GATWICK AIRPORT NORTHERN RUNWAY

HORSHAM DISTRICT COUNCIL'S RESPONSE: DRAFT ISSUES TRACKERS SENT ON 18 AUG 2023

15 SEPTEMBER 2023

SUMMARY OF ISSUES RAISED TO DATE

Local Study Area Map

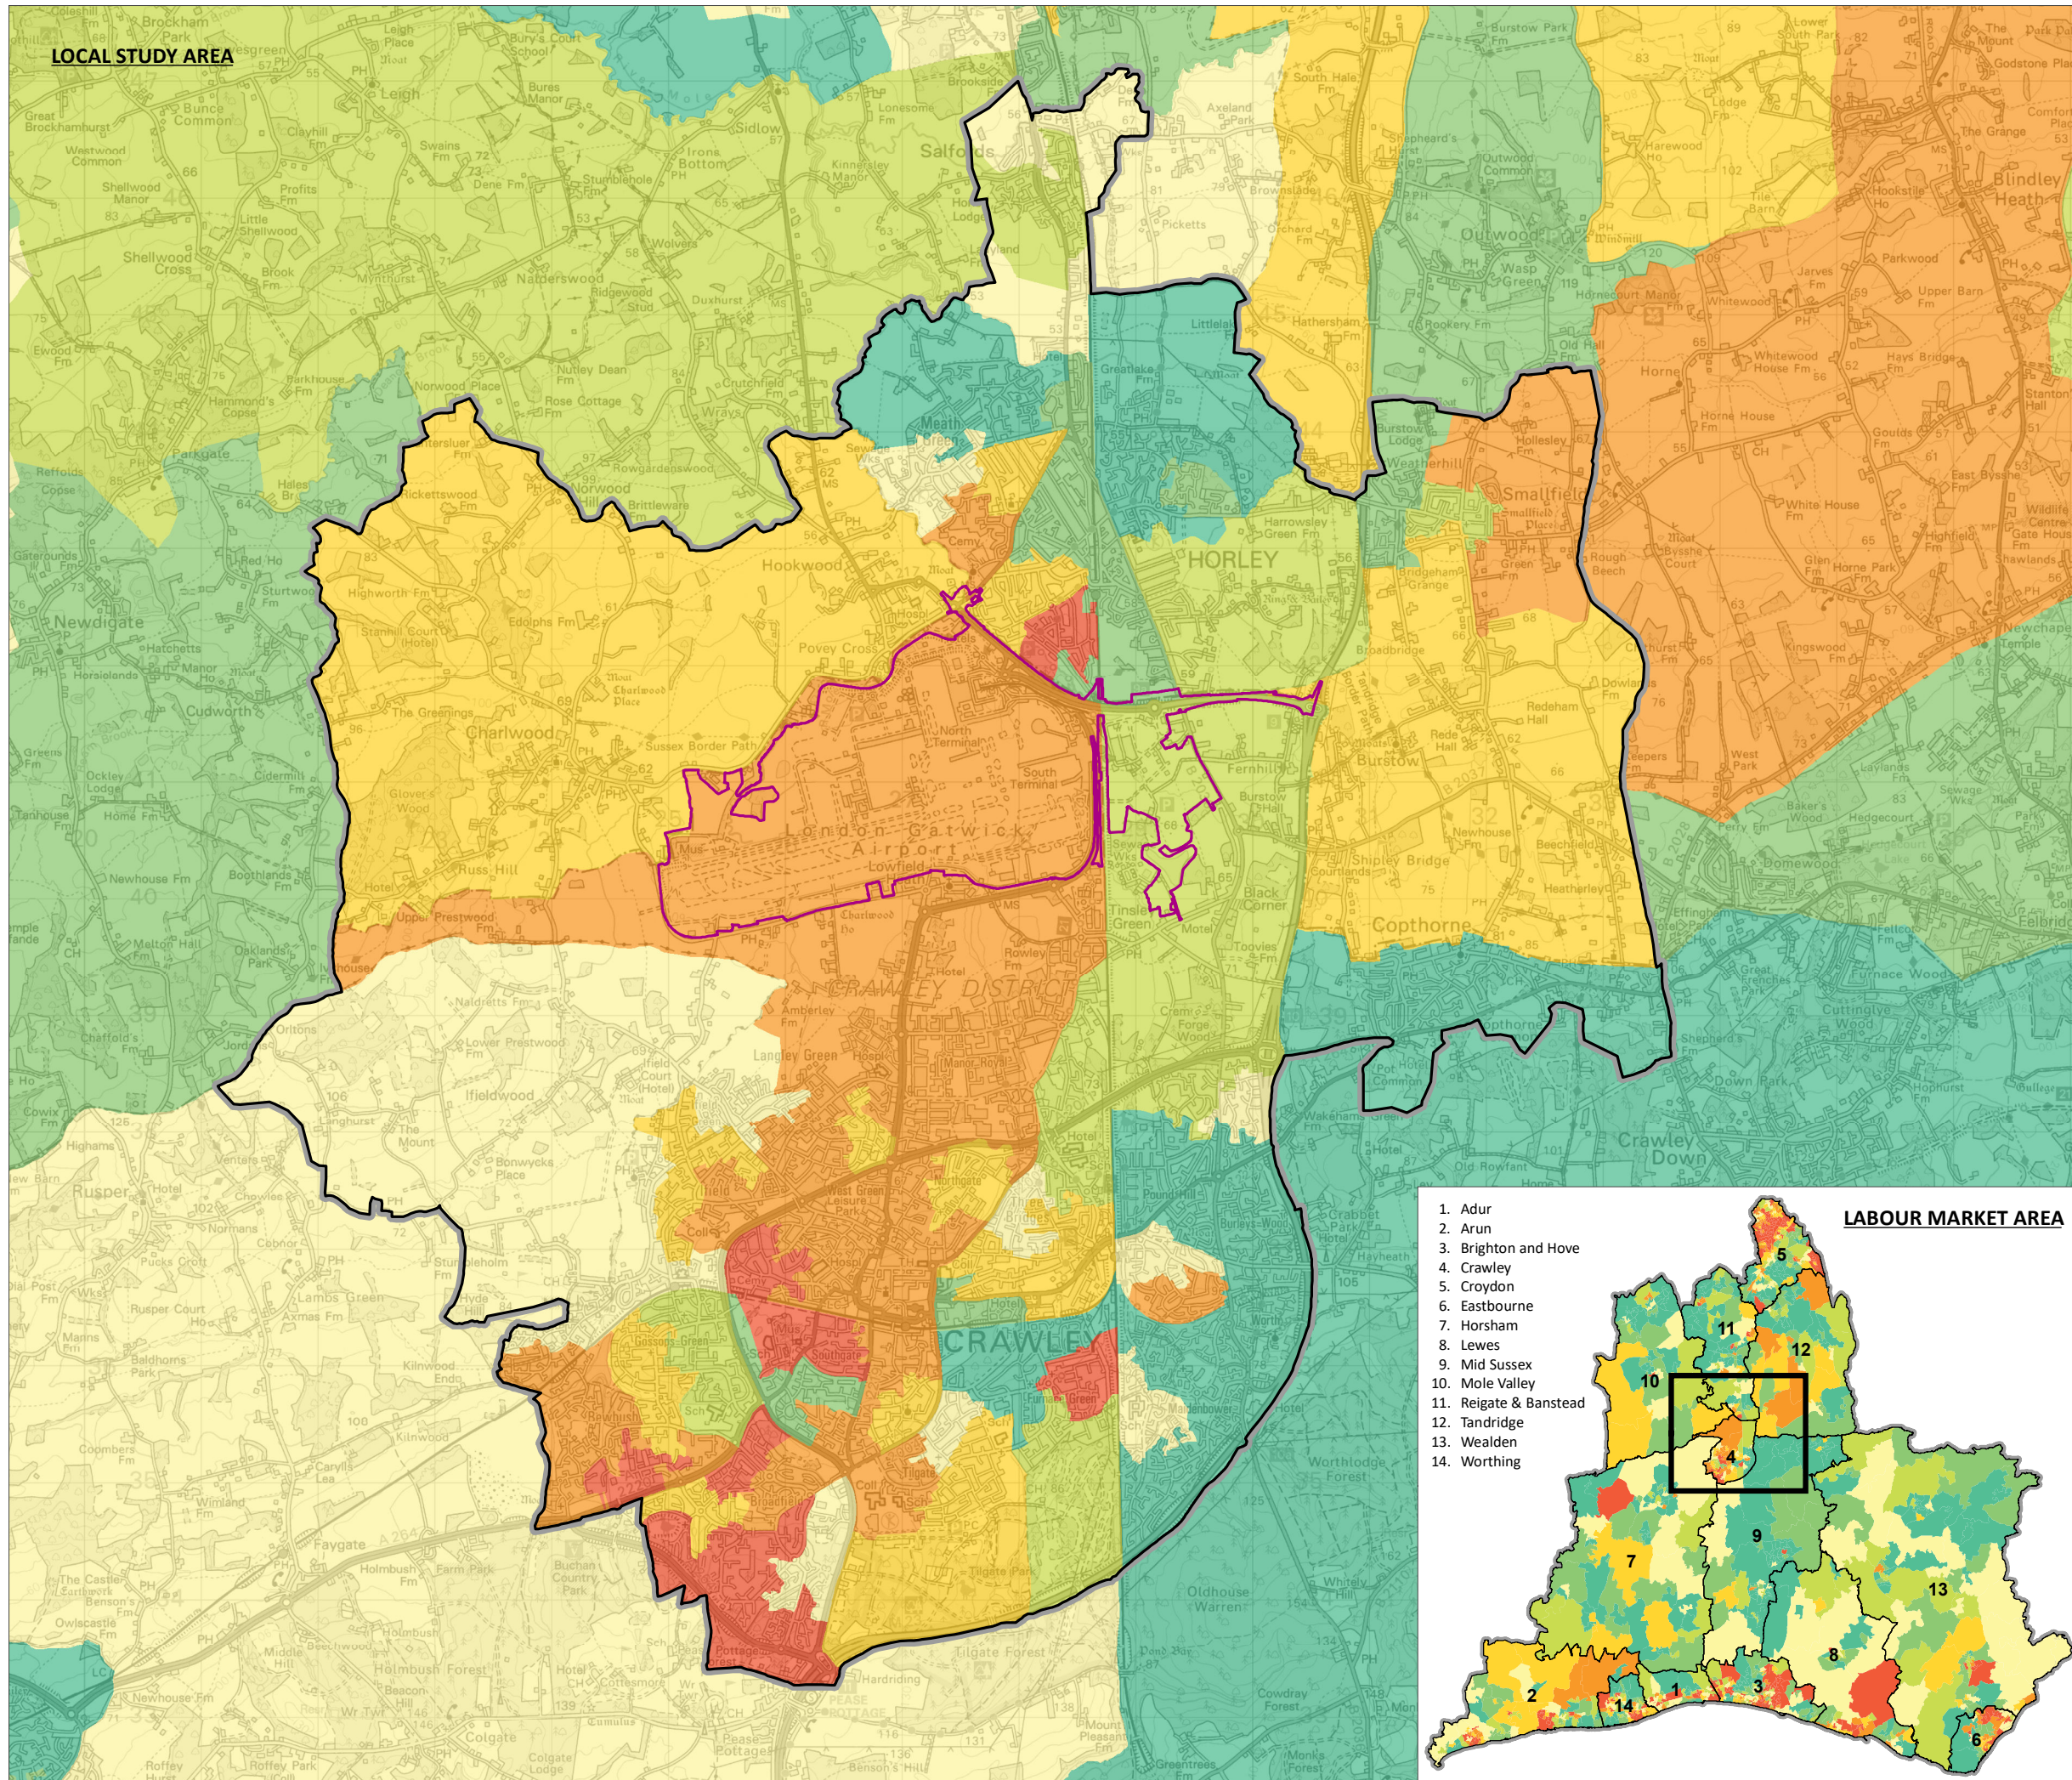
2. Labour Market Area is too large to allow local authorities to understand impact on own area.
3. Only a small rural area of Horsham District has been included in the Local Study Area – suggesting it covers six local authority areas is misleading.

13. Lack of mitigation on key transport routes within Horsham District – how this may impact local economy.
14. Promised discussion about the extent of the Local Study Area (TWG 1 May 2022, Slide 9) was welcomed, however engagement has not taken place.

23. More detailed explanation required of approach to catalytic employment taken.
24. Disagree with GAL's decision not to undertake assessments at a local authority level as will not capture sensitivities or impacts. As a minimum, GAL should assess the local authorities in closest proximity.
